Response to submissions for Bringelly Rd, Business Hub

Eco Logical Australia Pty Ltd (ELA) was commissioned by Western Sydney Parklands Trust to prepare a response to the submissions for the exhibition of the planning application for the Bringelly Rd Business Hub (BRBH). It is understood that exhibition of the development application for the BRBH ended on 2 March 2015 and Western Sydney Parkland Trust (WSPT) have been issued the submissions from relevant authorities, in which some require ELA's assistance in addressing.

Please find below our response to submissions from the Office of Environment and Heritage (OEH) and Liverpool City Council, relevant to the Flora and Fauna Assessment (FFA) for the BRBH State Significant Development (SSD 6324), prepared for WSPT by ELA (ELA 2014).

Figure 1: Location of the subject site in relation to biodiversity certified lands

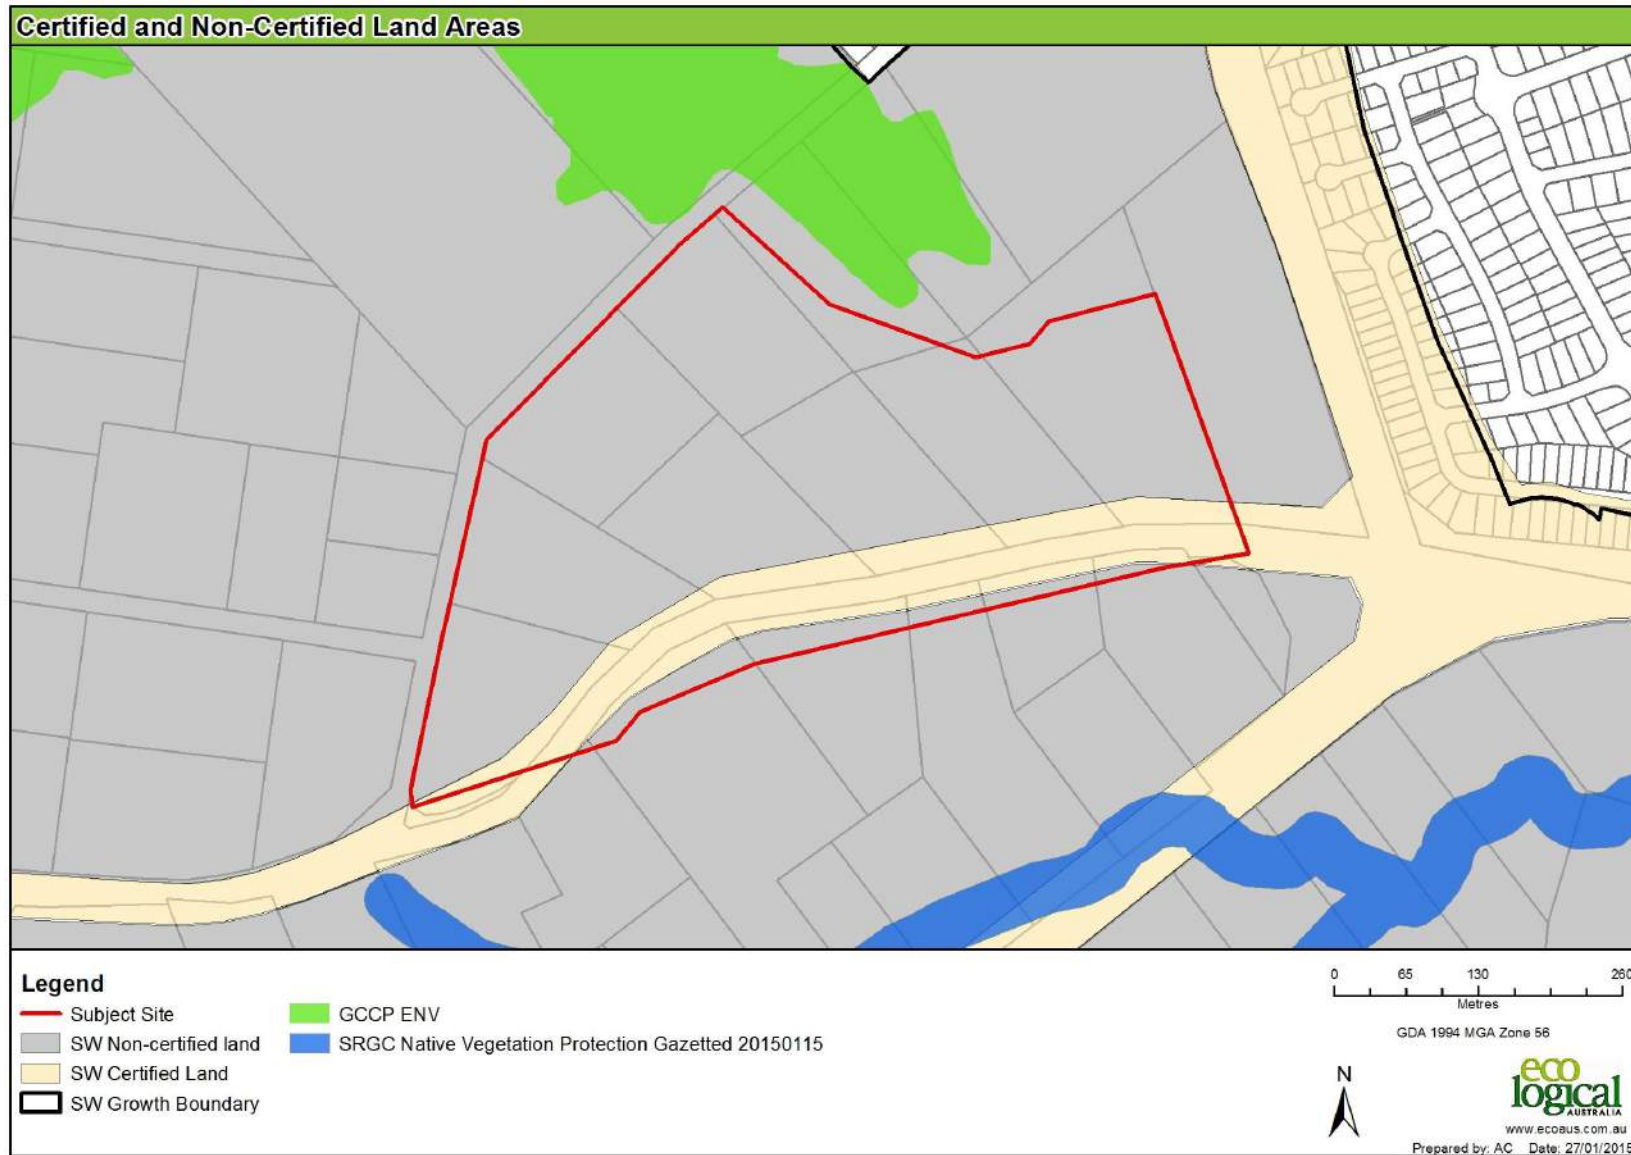
- 5. Neither the EIS nor Flora and Fauna Assessment specifically address the DGRs relating to assessment of the impacts of the proposal in regard to the Biodiversity Certification Order for the Sydney Region Growth Centres. However, Figure 3 of the Flora and Fauna Assessment identified existing native vegetation (ENV) as defined by the Order; OEH notes that no ENV would be removed by the proposed project.*

ELA’s response: The impacts of the proposal in regard to the Biodiversity Certification Order for the Sydney Region Growth Centres have been addressed in the BOS (ELA 2015). The subject site is located within both certified and non-certified land. The proposal will impact on 17.182 ha of non-certified land (for which the BBAM assessment has calculated 35 credits are required) and 3.878 ha of biodiversity certified land (which does not require any offsets as the land is certified). Although Figure 3 of the Flora and Fauna Assessment (ELA 2014) identified ENV to the north of the subject site, the ENV is located outside the study area, and no ENV will be impacted as a result of the proposal. Refer to Section 1.1 and Figure 1 of the BOS (ELA 2015).
